PORT ■ CITY
ARCHITECTURE

31 FORE ST Additional Conditions

C. SITE PLAN REVIEW

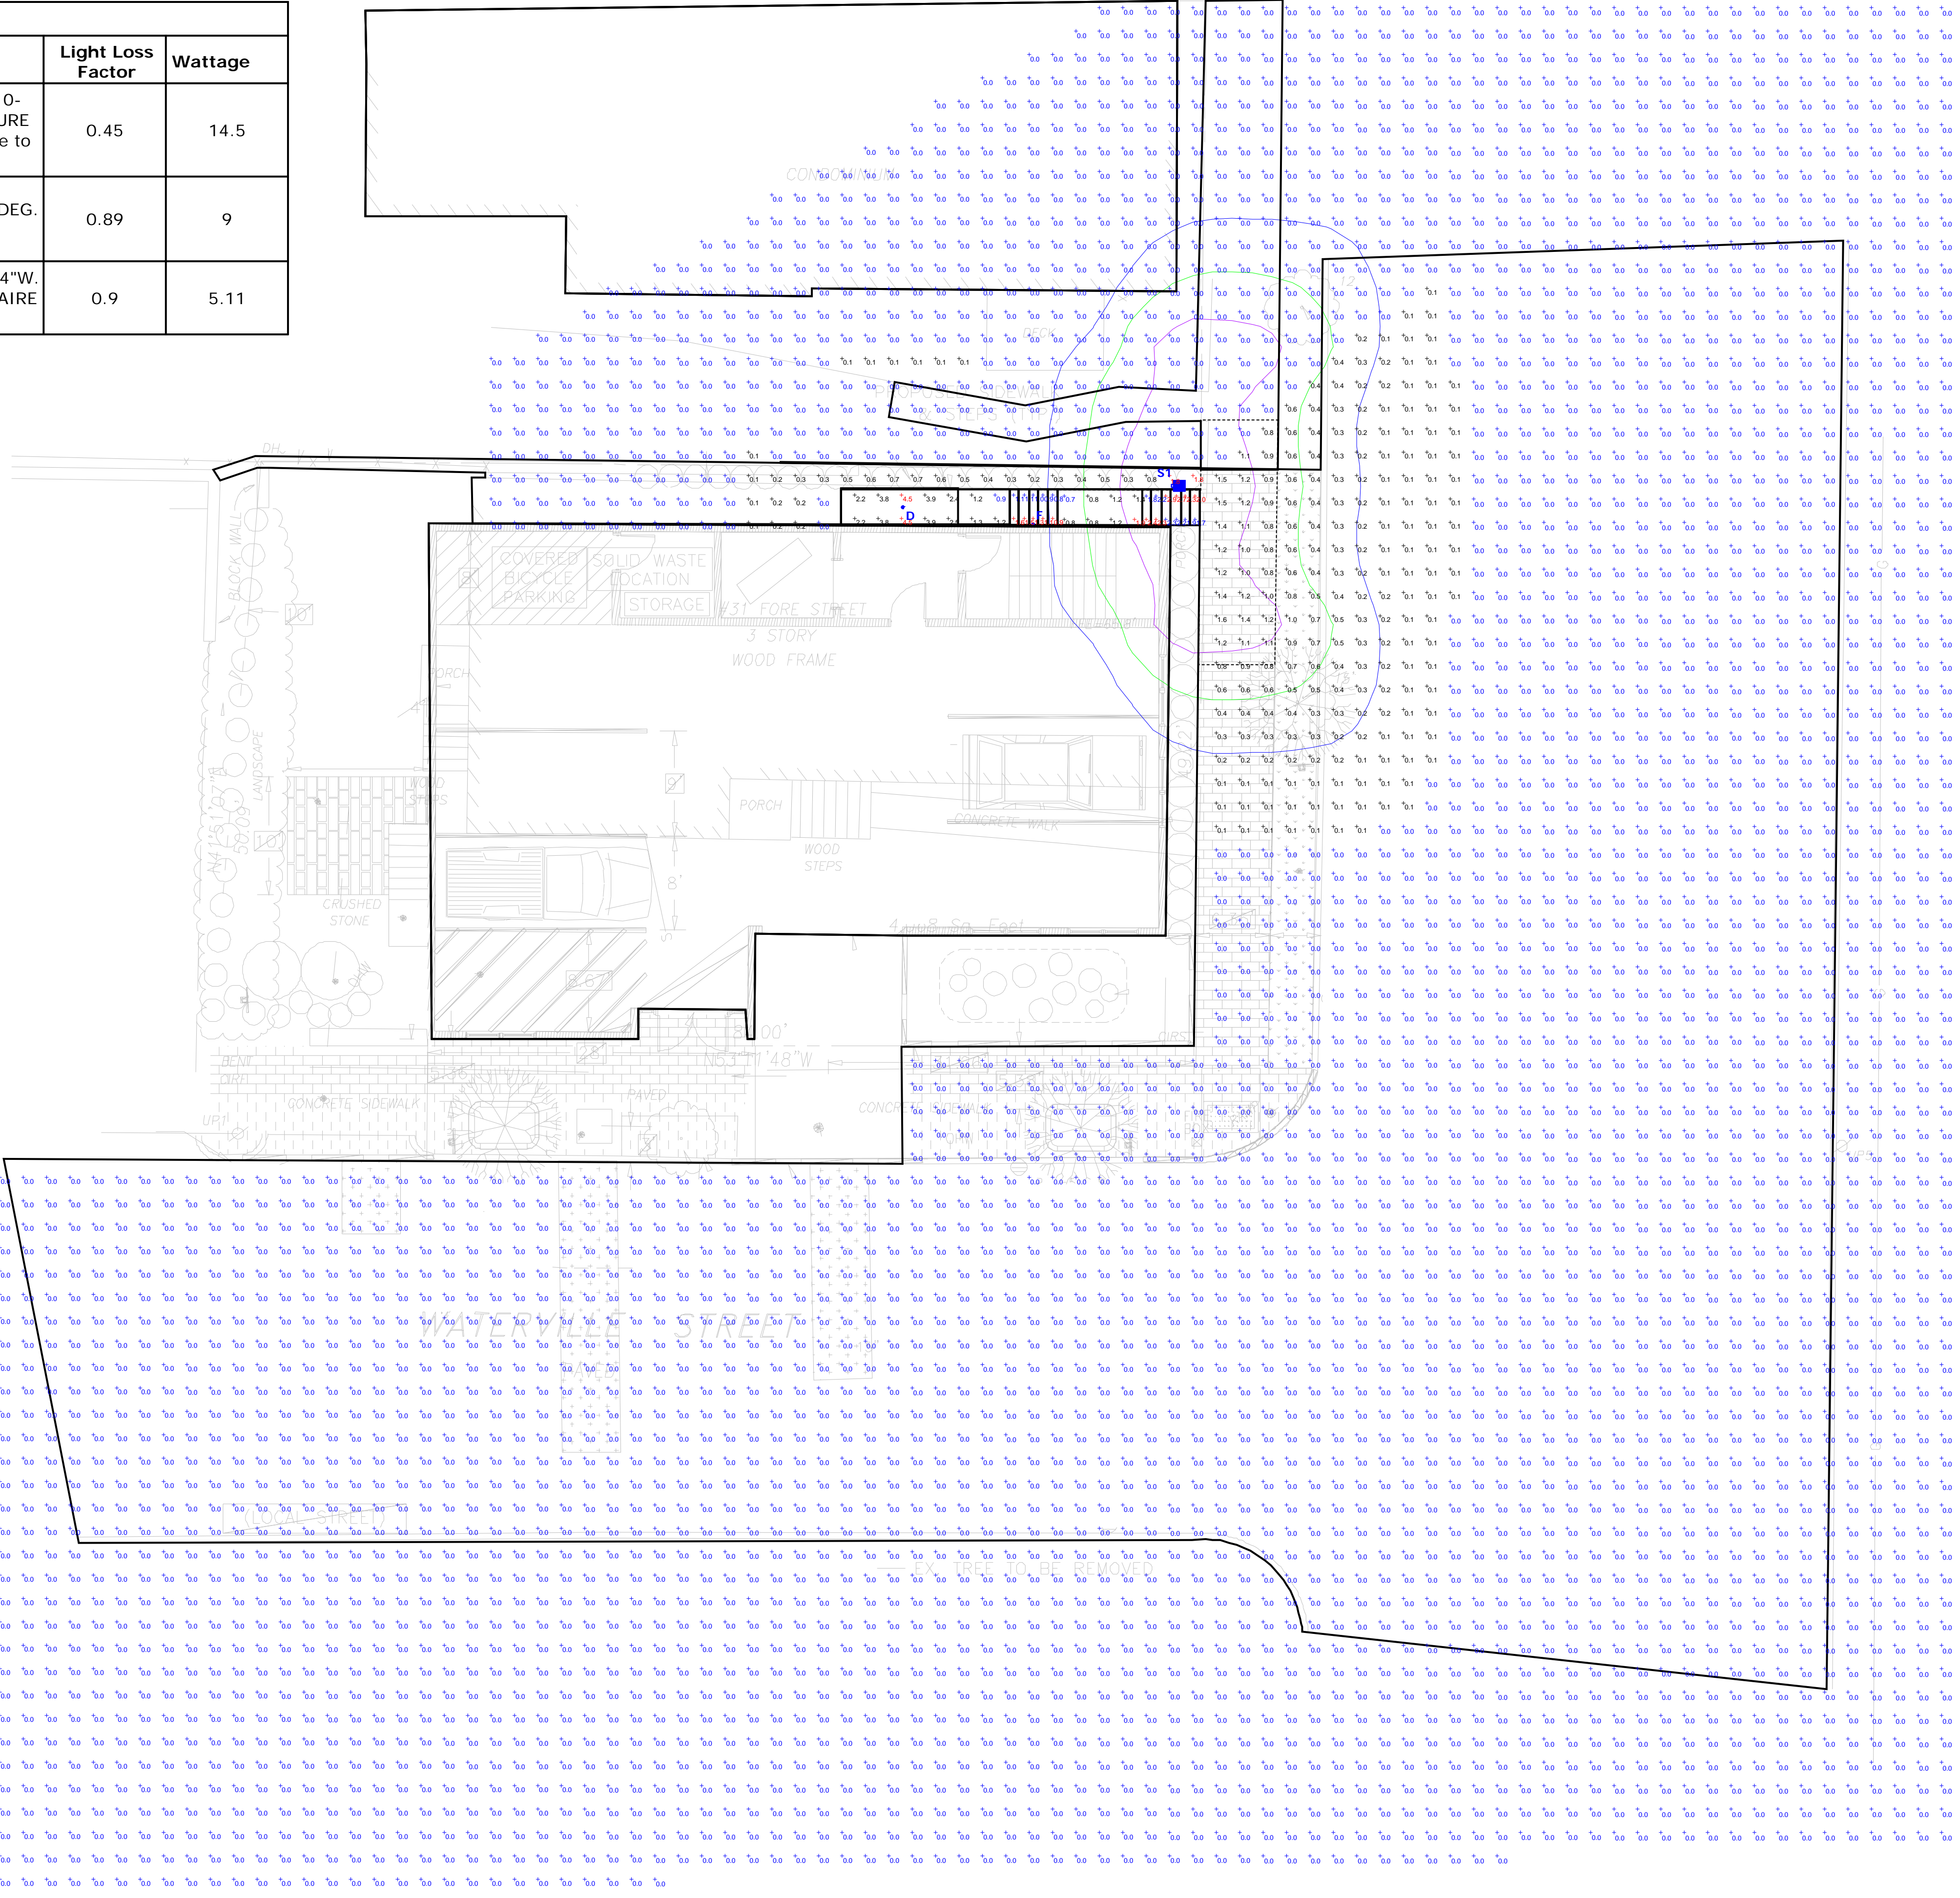
- i. That the applicant shall confirm which entrance is the main entrance and revise this main entrance to meet the R6 Design standards as outlined in the Design Review comments, and to meet the Site Lighting Standards of the Technical Manual, with the revised proposals submitted to the Planning Authority for review and approval prior to the issuance of a building permit.

The main entrance is now on the Waterville St side of the building. The entrance is marked with an overhead canopy with down lights, PA system and Building signage. (See below for rendering)
